**Re: Take 5 Oil Change at 1105 Snow Vista Blvd SW
Erosion and Sediment Control Plan
Engineer's Stamp Date 11/3/2023 (M09E012C)**

Based upon the information provided in your submittal received on 11/3/23, the above referenced ESC Plan cannot be approved until the following comments are addressed.

EROSION AND SEDIMENT CONTROL PLAN

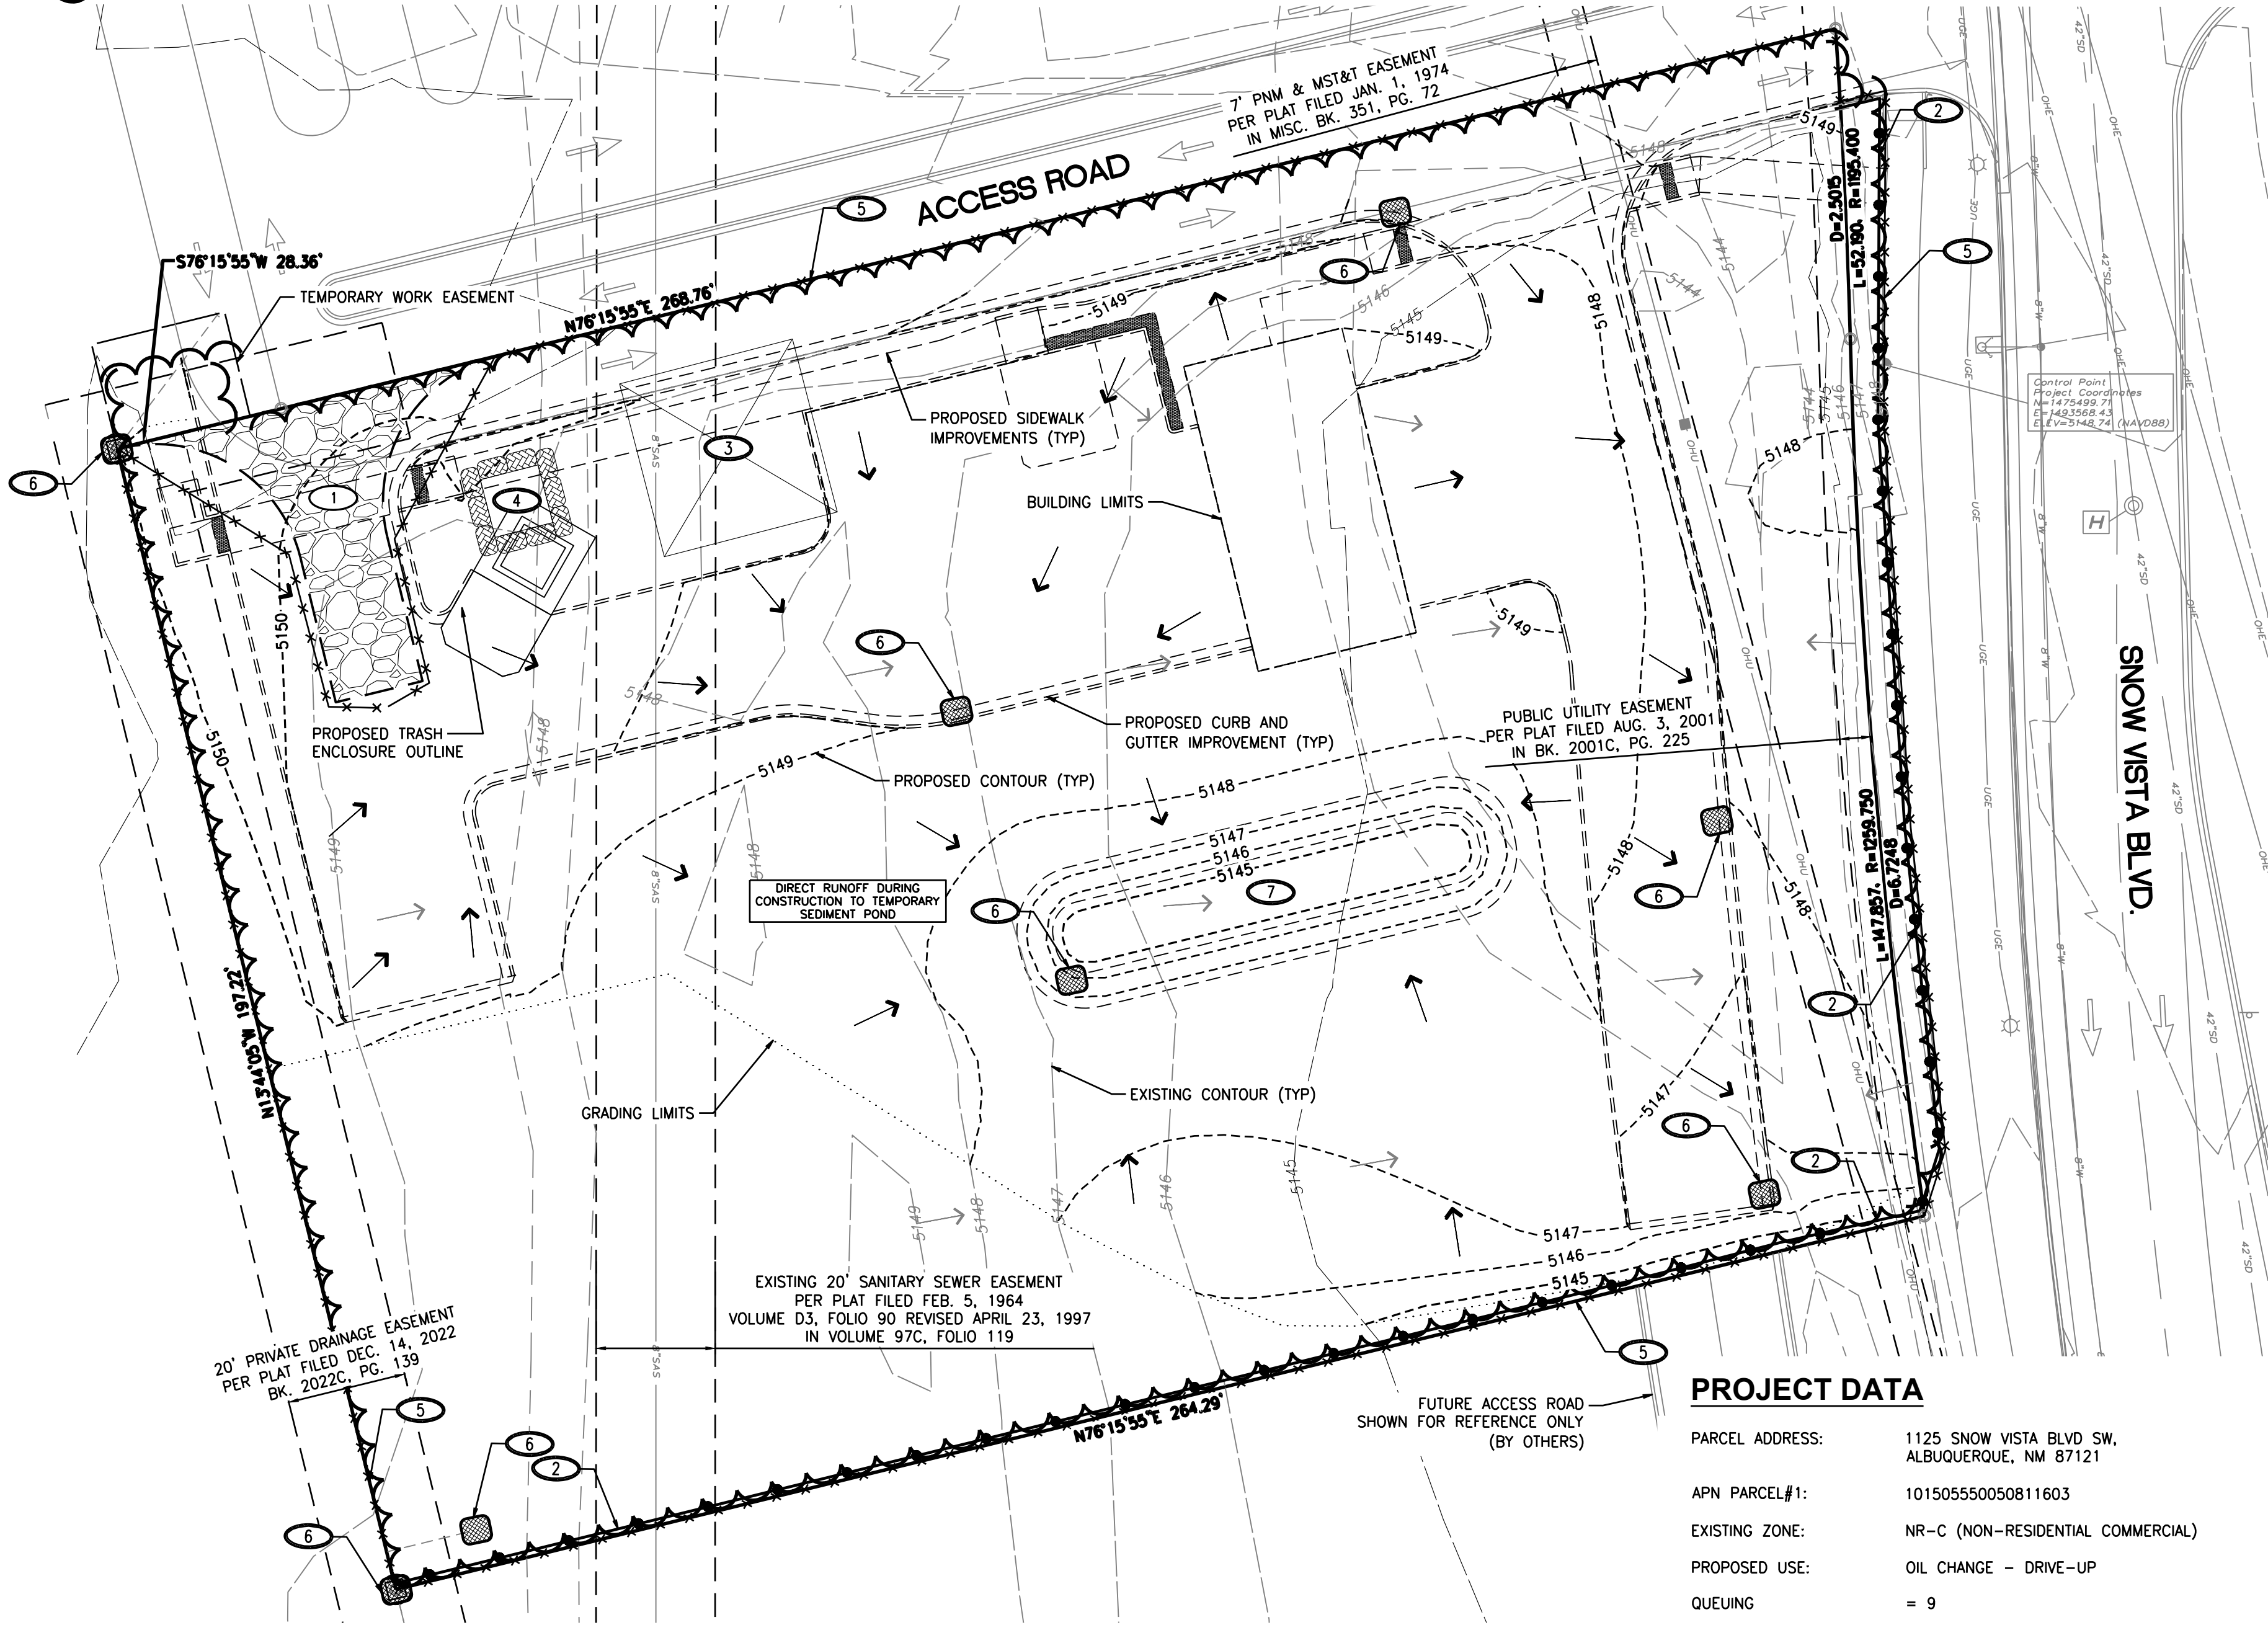
1. The ESC Plan can't be approved until after Hydrology approves the G&D Plan for each specific purpose, Site Plan, Grading, Building Permit, and Work Order. Hydrology's comments on the Conceptual G&D still haven't been addressed yet. The existing and proposed storm drain and the existing and proposed grades must be shown on the ESC Plan, and they must agree with the Grading Plan approved by Hydrology (CGP7.2.4.b.ii);

2. The SWPPP must include site-specific interim and permanent stabilization specifications per CGP 9.4.1.c.i. The Landscape Plan can be used to satisfy this requirement and should be submitted separate from the ESC Plan with the application to the Stormwater Quality Section of the Planning Department and they should be included in the SWPPP. Provide a specification on the ESC Plan for any disturbed areas not covered by the Landscape Plan.

3. The owner information shown on the Information Sheet does not agree with the available Bernalillo County records. The accurate name and contact information for the entity in control of the property rights is required and should also be shown on the Information Sheet, the NPDES documentation. Property rights may have changed hands recently, if so, please provide documentation in the form of a recorded deed or lease. The property owner's NOI is required. The individual signing the NOI must satisfy the requirements of CGP G.11.1 and all other documents in the SWPPP must be certified per CGP G.11.2-4.

4. Update the engineer's stamp date each time the plan is changed.
